Your Ref: BE/102/17/OUT

Re: Salt Box Field, Land off Rowan Way, Bersted.

Thank you for your correspondence of 16th August 2017, advising me of a planning application at the above location for a Hybrid application comprising Outline application for development of employment units, warehouse, hotel, 2No. drive-thru units, public house, gym plus engineering works, landscaping & associated works. Full application for a Warehouse (class B8), fuel island, car parking, and access roads with new entrance from Shripney Road plus engineering works, open space, landscaping & associated works, for which you seek advice from a crime prevention viewpoint.

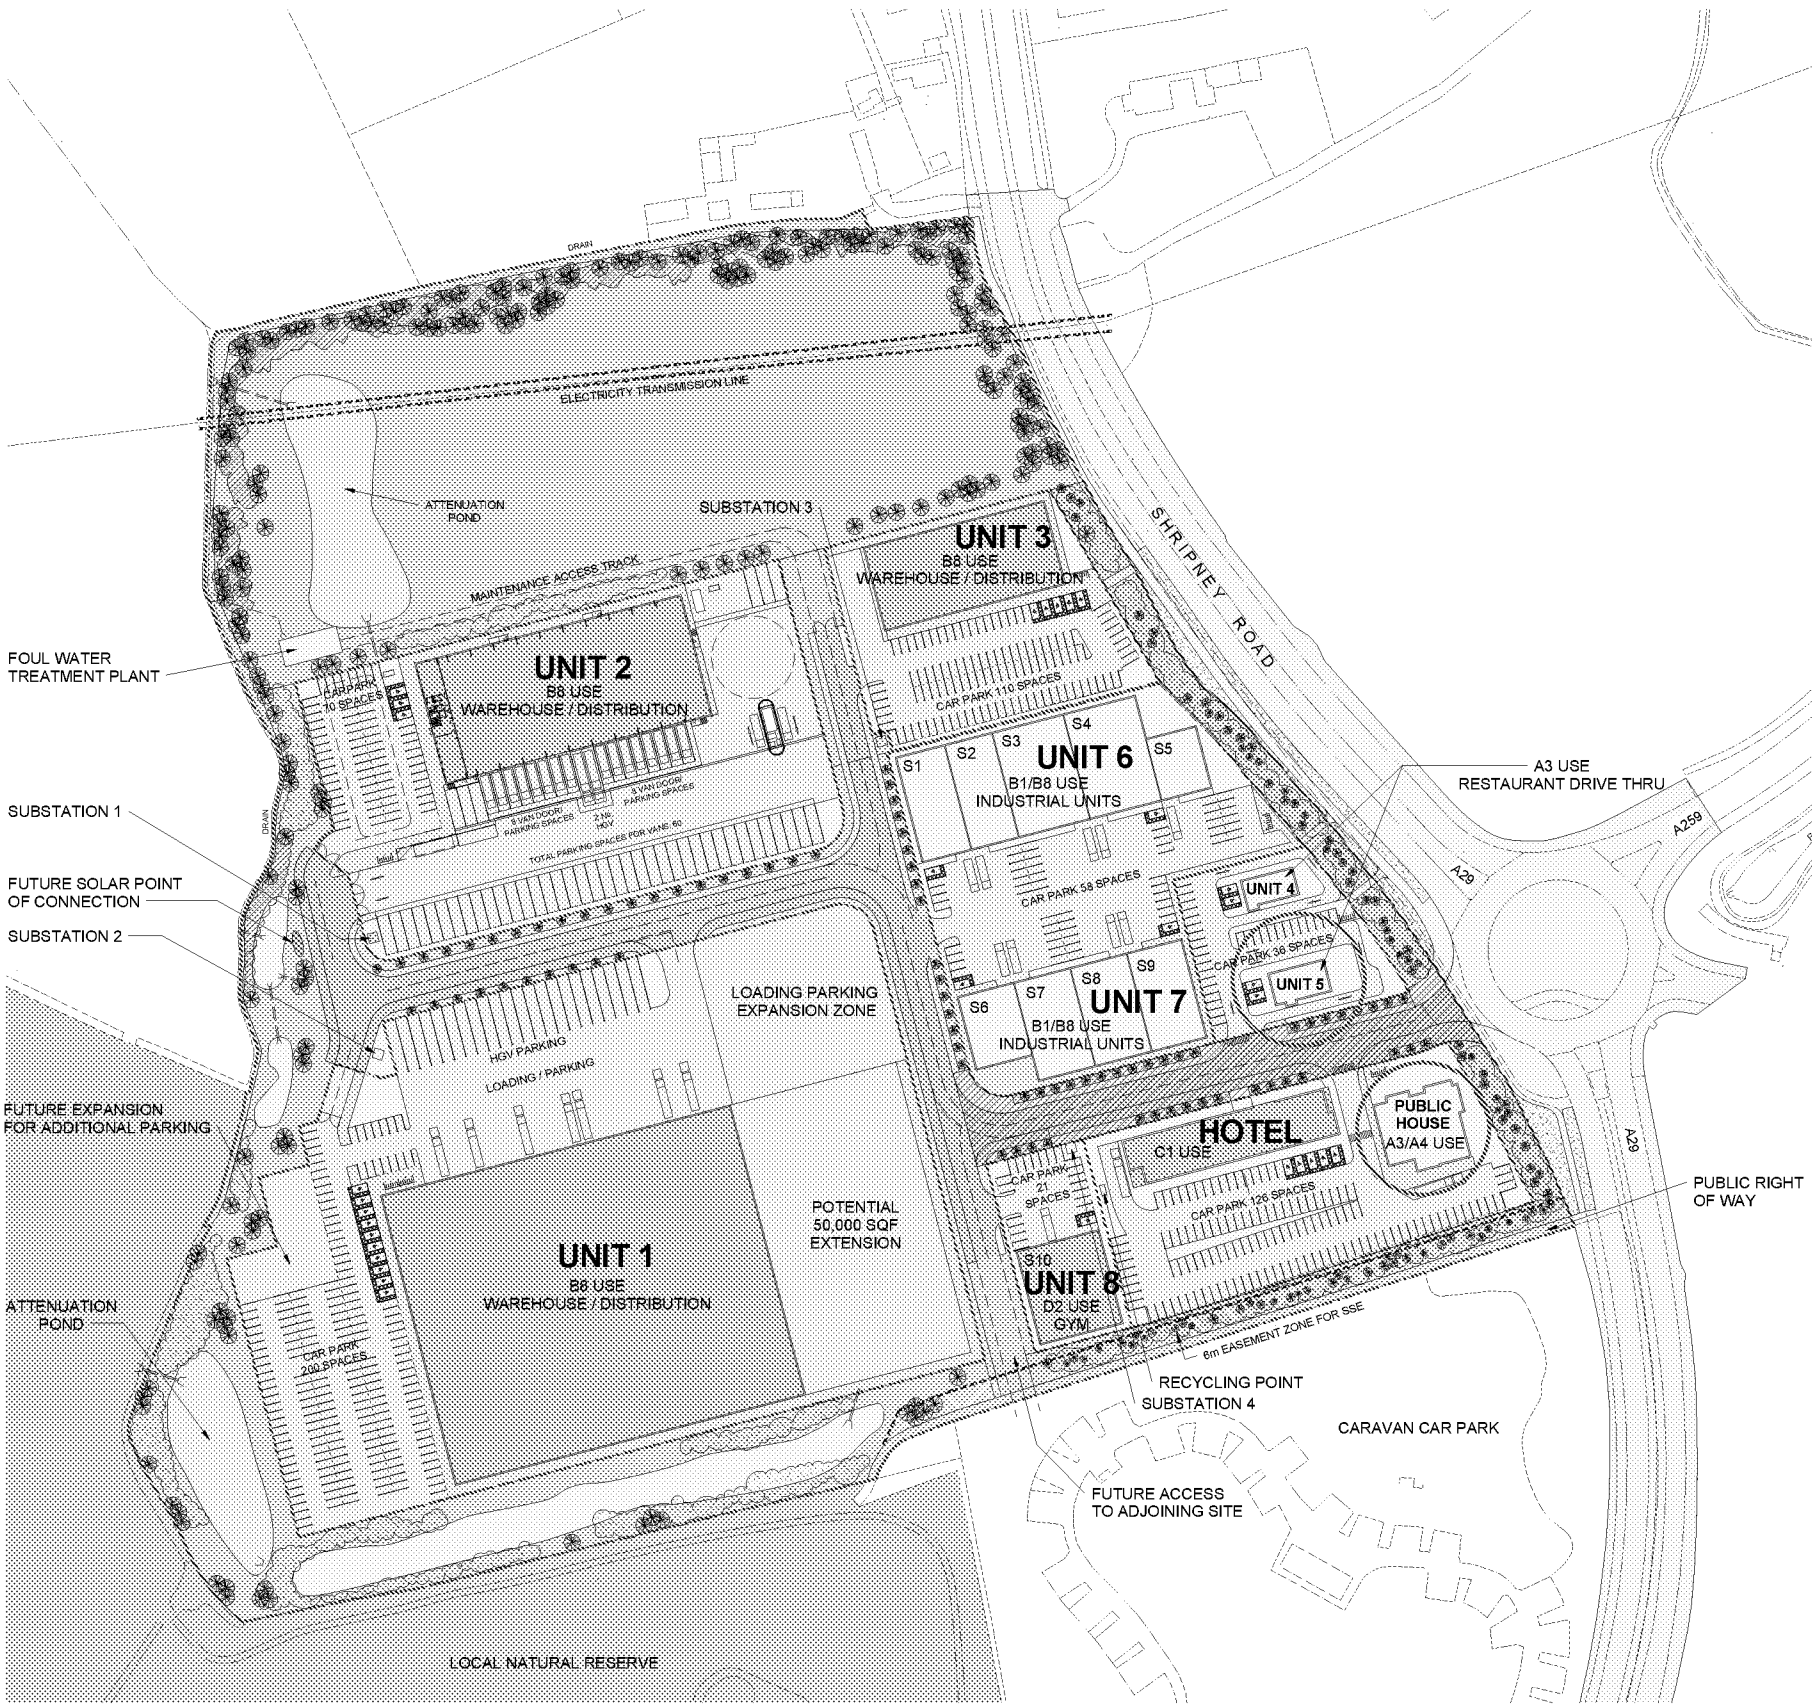
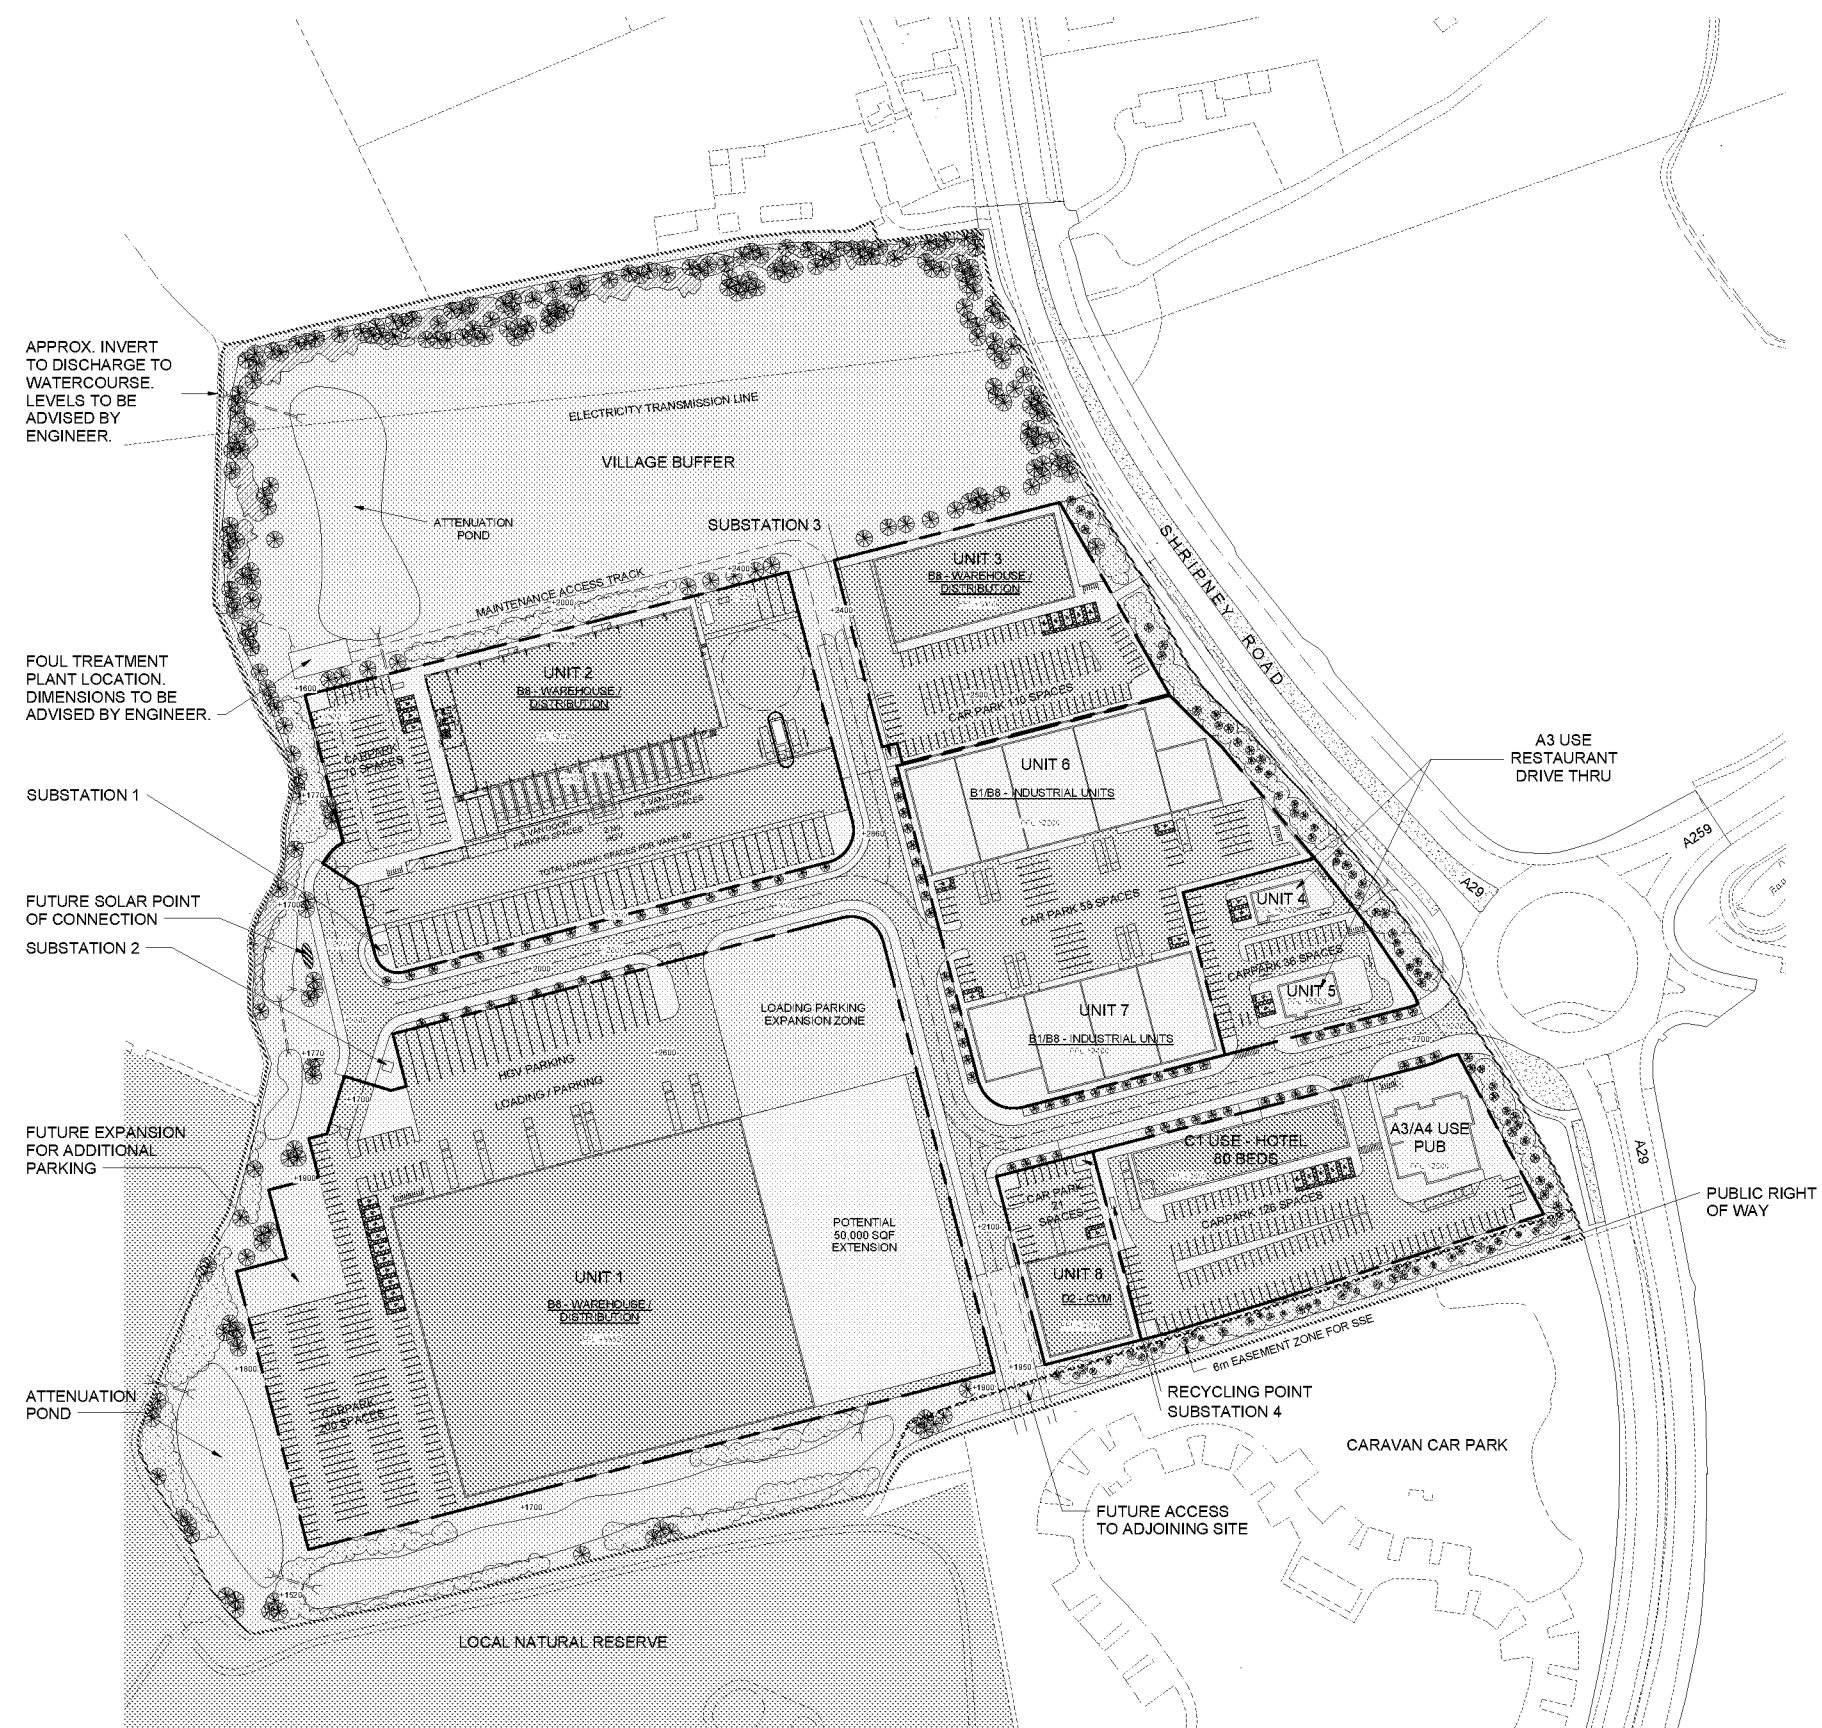
I note that warehouse unit 1 has a perimeter fence with a gated entrance at its western end. I would recommend that its northern entrance also has controlled gated access to deter unauthorised persons and vehicles entering the loading / manouvering areas and staff car parking areas.

Consideration should also be given to a controlled pedestrian access from Shipney Road and also to the car park entrance into Warehouse Unit 3 to prevent unauthorised persons entering the industrial units. This will also benefit security for cycle racks near the Shipney Road access.

Between Industrial Units 6 & 7 I would recommend there is a substantial fence or dense planting to ensure there is no access from the public areas Units 4 and 5 (Restaurant and Drive through) and associated car parks as this area provides potential easy access to the staff car parking areas of units 6 & 7 and the back of the industrial units.
